**KIRKLEES METROPOLITAN COUNCIL
INVESTMENT & REGENERATION SERVICE**

DELEGATED DECISION TO DETERMINE PLANNING APPLICATIONS

Reference No:	2025/62/90065/E
Site Address:	6, Summers Drive, Mirfield, WF14 0DY
Description:	Installation of air source heat pump and roof fitted PV solar panels
Recommending Officer:	Jennifer Booth

DECISION – CONDITIONAL FULL PERMISSION

# Heat Pump Location - 6 Summers Drive WF14 0DY

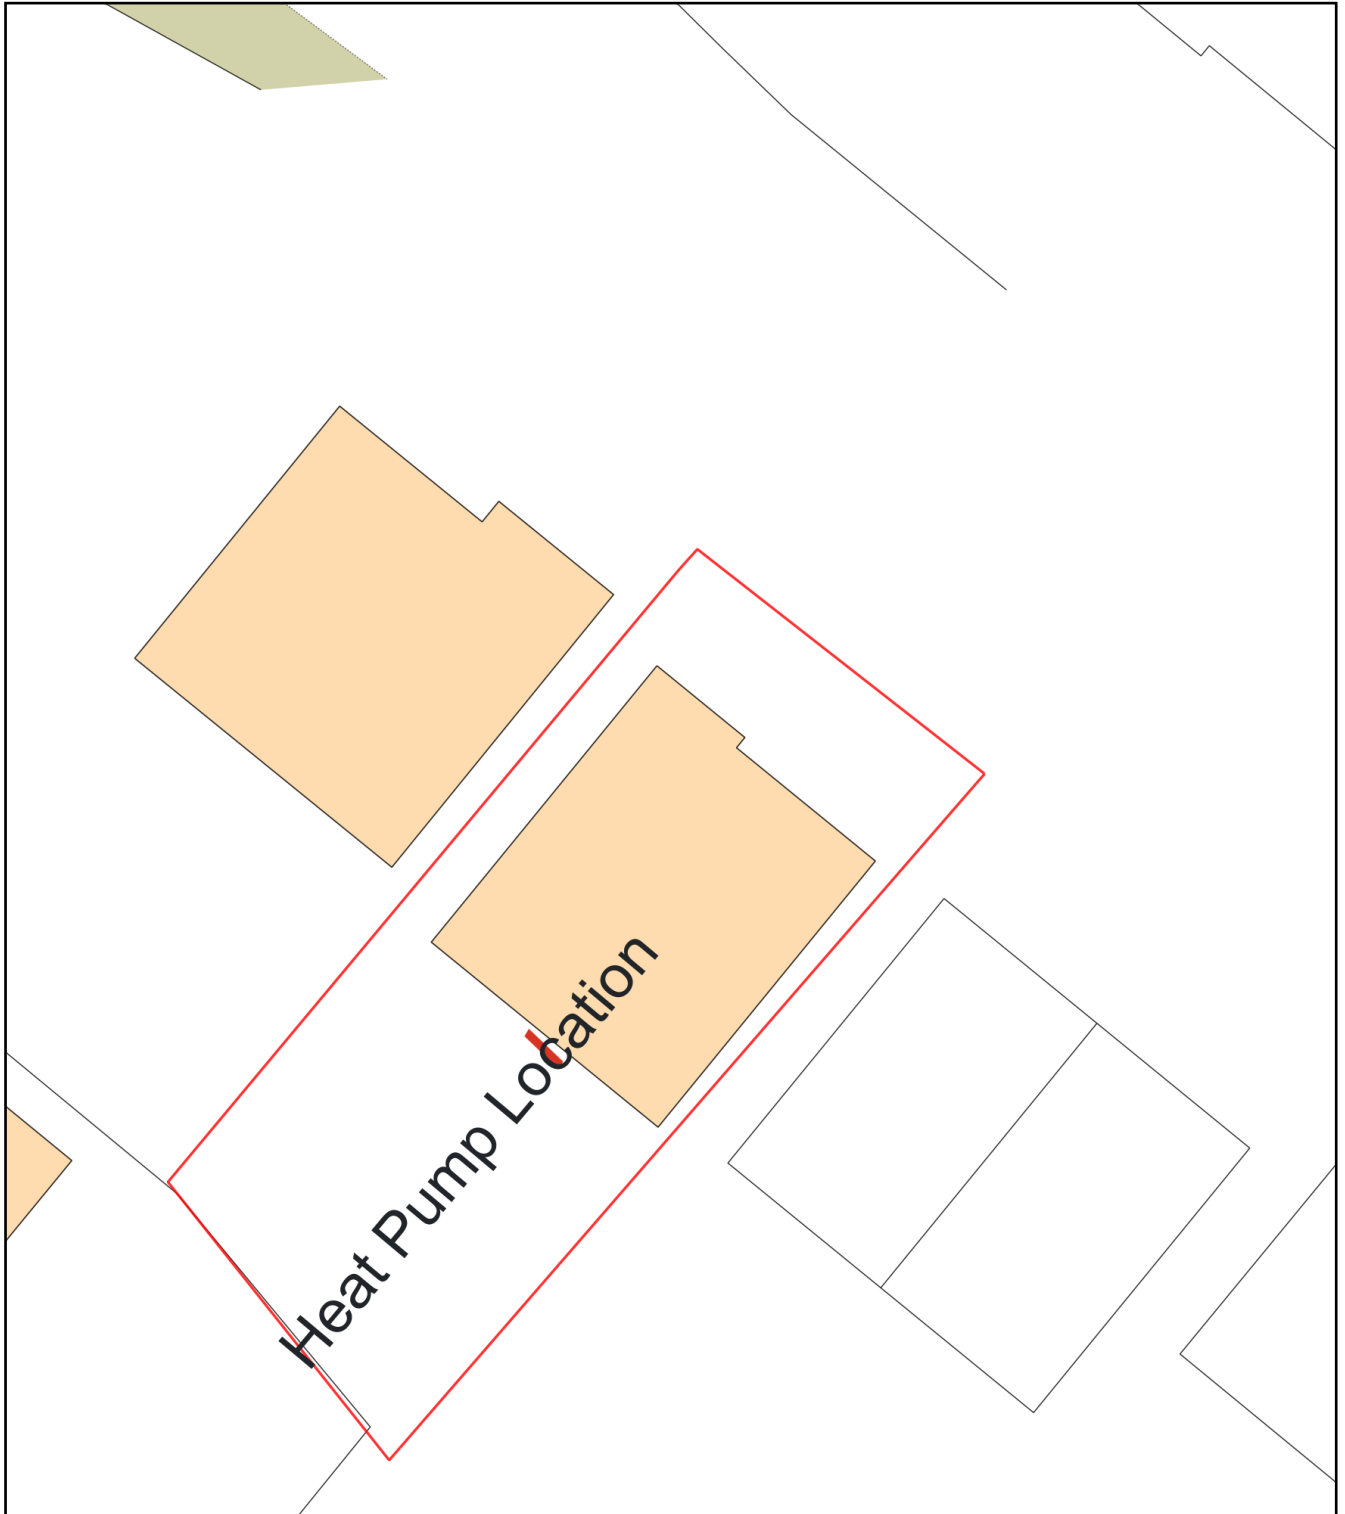
K.C. Environmental Health – concerns raised regarding noise. Informally discussed mitigation and EH suggested a screen, located to the side of the unit would overcome the concerns

Based on the manufacturer's specifications, the anticipated operational noise levels of the ASHP are likely to exceed the generally accepted external daytime noise threshold of 42 dB at the nearest noise-sensitive receptor. While this raises a potential concern in terms of residential amenity, the applicant has submitted further details demonstrating how this impact would be mitigated. Specifically, the proposal includes the installation of an acoustic screen to be sited immediately alongside the ASHP unit, positioned between the unit and the shared boundary with No. 8.

The applicant was asked to provide a screen at the side of the unit as the noise levels would exceed permitted levels. The alteration is minimal and has not been advertised.

Screening to the side of the air source heat pump should be conditioned to be installed prior to first use of the unit and retained to ensure the appropriate mitigation of noise impact.

3. The screening shown on plan titled 'proposed noise reducing plan for 6 Summers Drive, Mirfield. WF14 0DY' submitted on 12/06/2025, shown sited to the side of the air source heat pump hereby approved shall be installed prior to first use of the air source heat pump and retained thereafter.
